APPENDIX 2 to Overview – REP3-xxx

RHS response to REP2-014 Deadline 2 Submission - 9.19 Applicant's Comments on Written Representations

Figure 9.2 All accidents within 1km of M25 junction 10

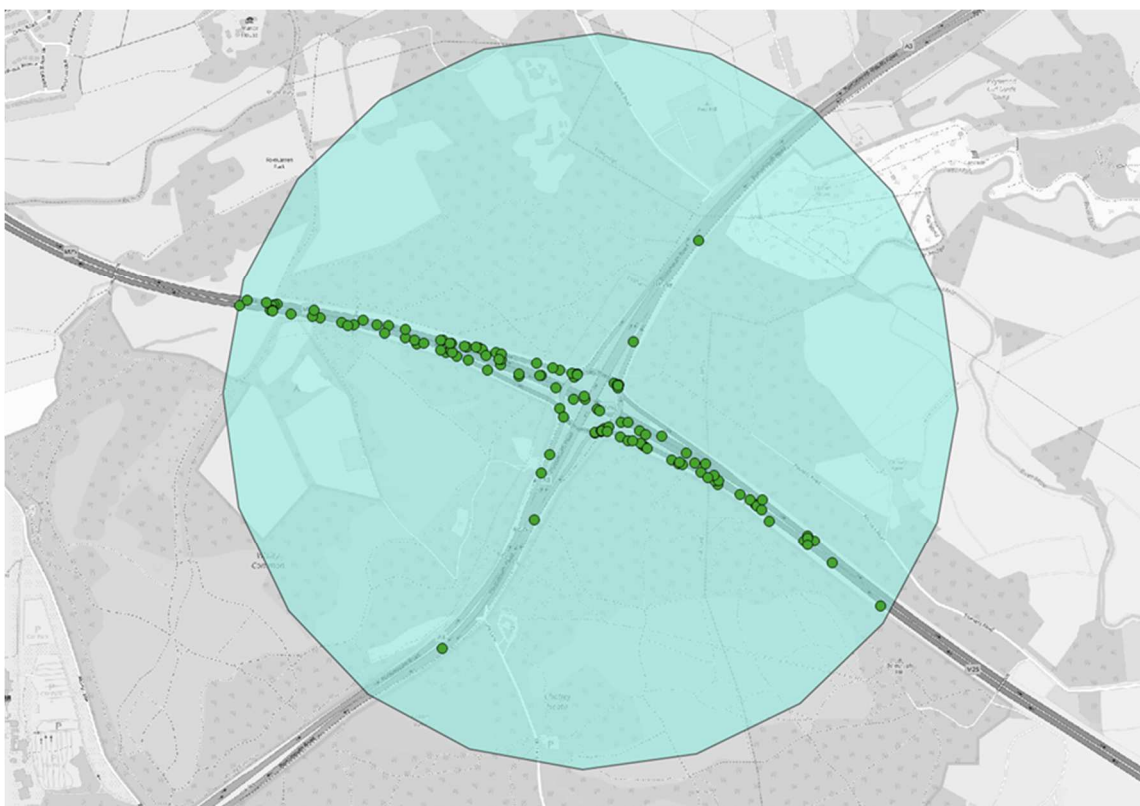
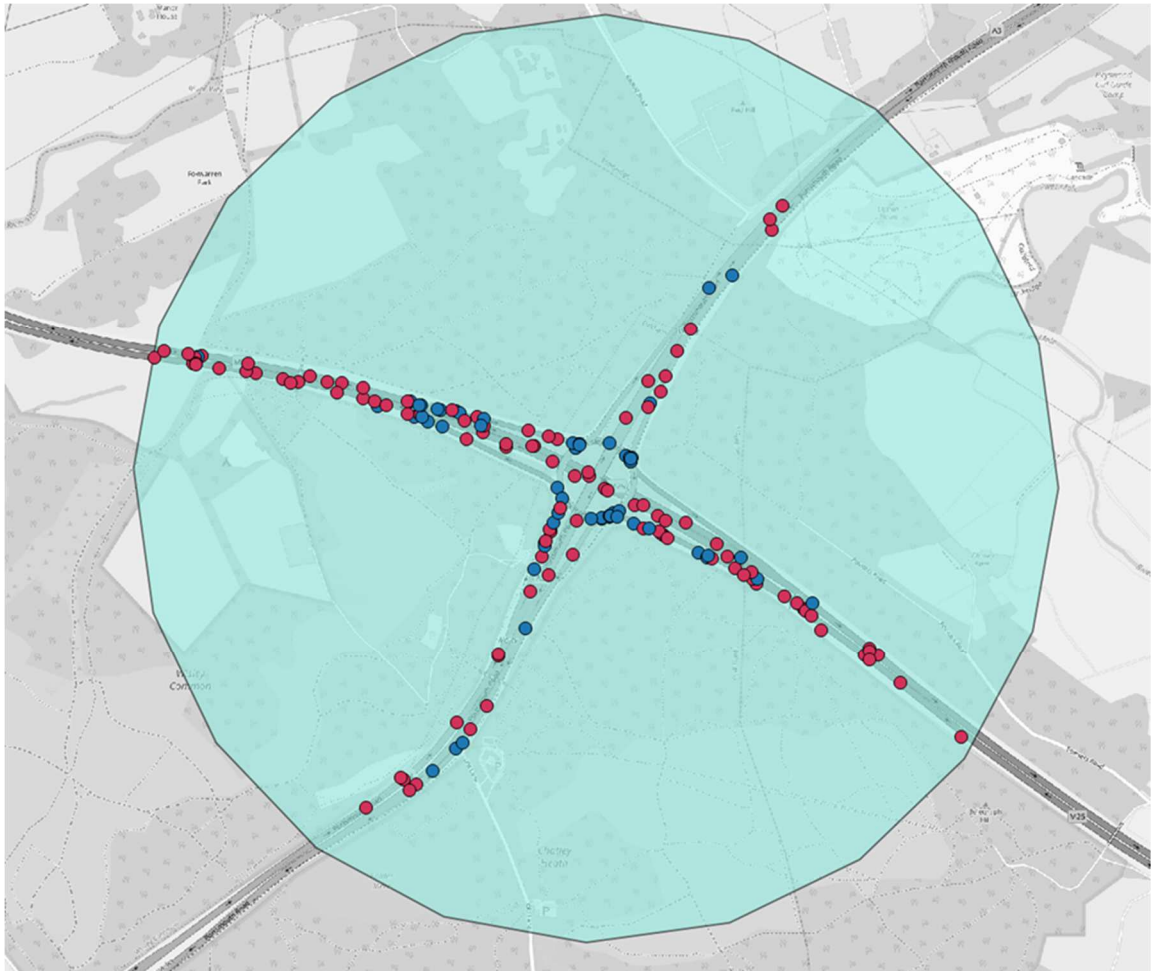
<p>However, a check against the Accident Plot provided by the Applicant on the last page of its September 2019 Technical Note (Appendix B of REP1-044) shows that with the exception of just 1 accident, the Applicant has incorrectly assumed that every accident which has occurred on the A3 from Wisley Lane to a point 900m north has been a result of the Wisley Lane junction, which clearly cannot be the case – as set out above, most of these are “shunt” type accidents related to queuing back from Junction 10.</p> <p>Further discussions are being undertaken with the Applicant in this regard in order to advance the SoCG.</p> <p>Journey distances have been checked against the Applicant’s CAD plans and it is expected in conjunction with the SoCG that the key distances north and south will be agreed.</p> <p>Trip distribution data in relation to RHS-related activity has been collected by different sources by the Parties and, although similar, these sources are not directly comparable. There are discussions ongoing in respect of the SoCG which seek to ‘narrow the gap’ between these sources.</p> <p>This, along with traffic modelling of RHS trips, will then be used to provide an agreed range of potential effects of the DCO Scheme in respect of the changes in vehicle travel and to consider the wider safety implications of the DCO Scheme and RHS Alternative.</p>

MERGE (SOUTH SLIP)

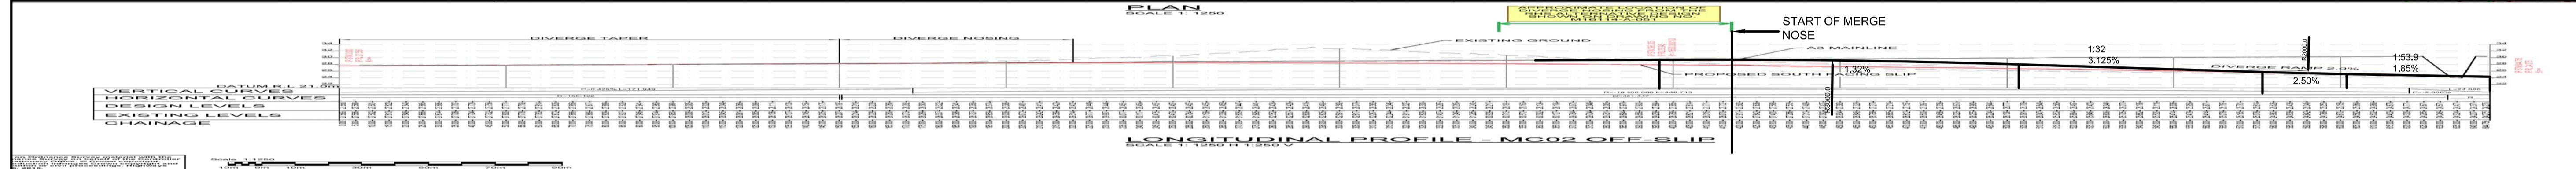
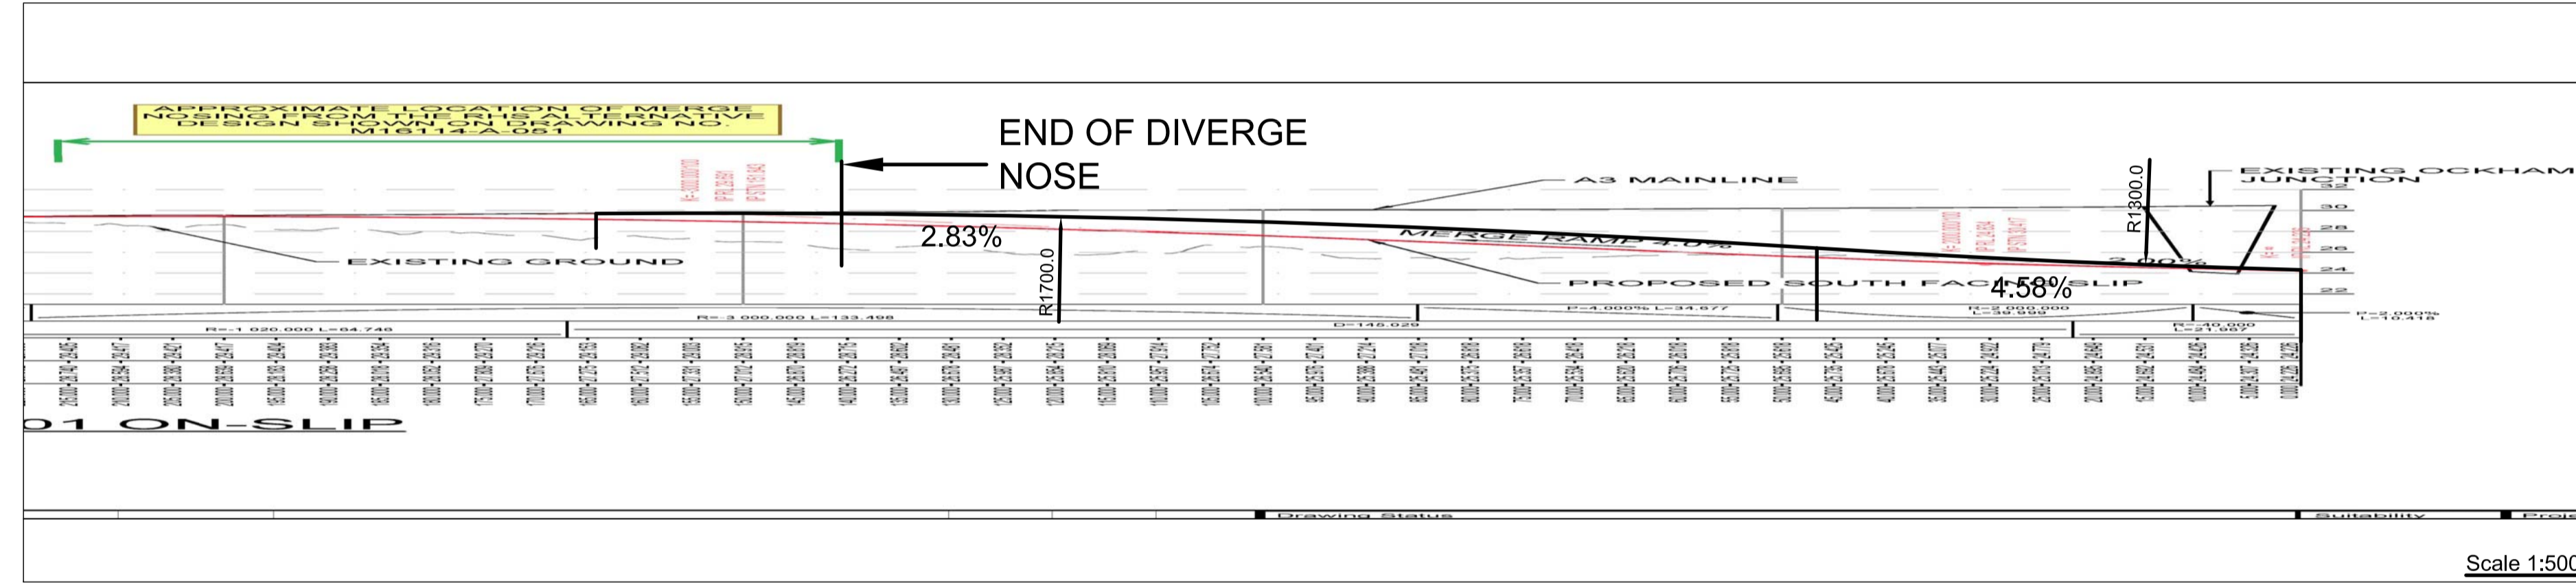
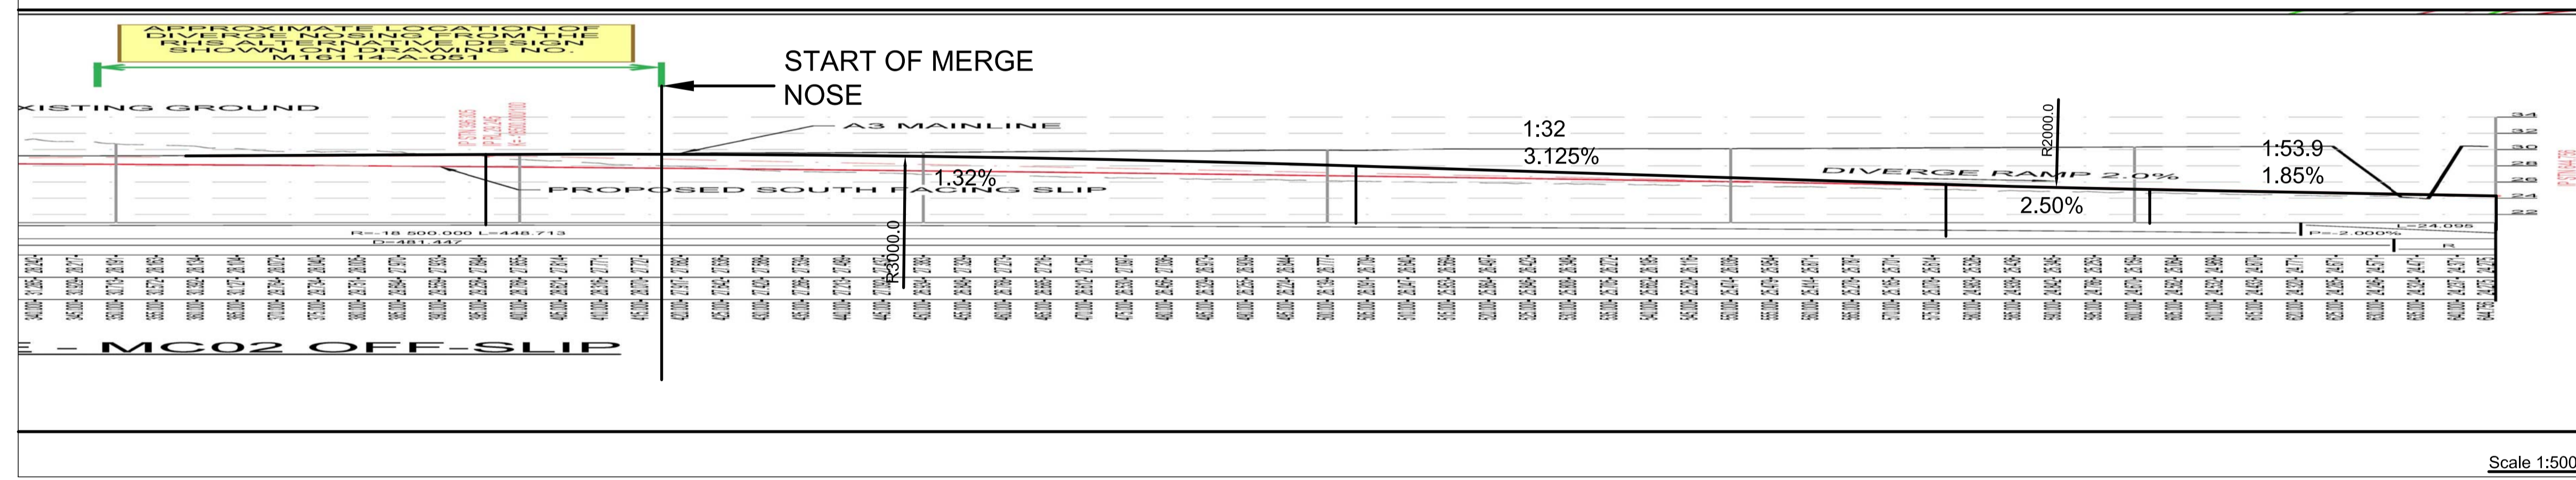
<p><i>South facing slip</i></p> <p>Please see response to Questions 1.13.6, 1.13.7, 1.13.11, 1.13.15, 1.13.18 of the Highways England's the Examining Authority's Written Questions (Volume 9.18). <i>Retention of Wisley Lane's direct "left out" connection to the A3</i></p> <p>We have demonstrated in the schematic provided in our Technical Note dated September 2019 that the actual weaving length (Lact) is only 953 m. The minimum weaving length required by design standards is 1 km and therefore the RHS Alternative scheme does not comply with the appropriate standards.</p> <p>With regard to weaving, we disagree with the suggestion by RHS that it is only the Wisley Lane traffic which is heading northbound on the A3 towards London which actually results in a weaving component from the slip. There will be traffic joining the northbound A3 from the Ockham Park junction wishing to get from Lane 1 and Lane 2 to Lane 3 and Lane 4 to continue north into London on the A3. There will also be traffic in lane 3 and subsequently lane 4 through and beyond the Ockham Park Junction that will want to access the diverge leading to the M25. The introduction of a merge from Wisley Lane will introduce additional vehicles and weaving movements, which drivers will not be expecting. Therefore, it will increase the risk of accidents, particularly because the vehicles merging from Wisley Lane will be slow moving.</p> <p>Highways England maintains that TD42/95 is the design standard for Major/Minor priority at grade junctions, which is what this particular element of the Scheme should be, but the design standards do not allow this type of junction on Dual 3 lane All Purpose (D3AP) roads and therefore by implication it is not permitted for use on Dual 4 lane All Purpose (D4AP) roads. As proposed by RHS, Highways England maintains that CD122 is not the correct design standard to be used for the RHS Alternative Scheme.</p>	<p><i>South Facing Slip</i></p> <p>Whilst it is noted that the Applicant states (within REP2-013) its proposals do not preclude the future implementation of the south facing slips at Ockham, they note various 'challenges and constraints' to their delivery. This is within the context of more than 3 years of design development which has sought to address similar issues elsewhere within the DCO Scheme.</p> <p>Firstly, third party land would be needed to provide south facing slips at Ockham but such issues have not prevented the promotion of the DCO Scheme where third party land is of course required for other components of the proposals.</p> <p>The enlargement of the Ockham Roundabout (to deliver south facing slips) is as shown on the attached plan (TTHC drg M16114-A-052A). The modifications within the Flood Zone are relatively modest, particularly within the context of the new Wisley Lane link provision.</p> <p>In respect of the weaving distance to Ripley Services, TTHC drg M16114-A-051 shows one means of how the 1km weaving distance could be achieved for both directions of travel on the A3.</p>
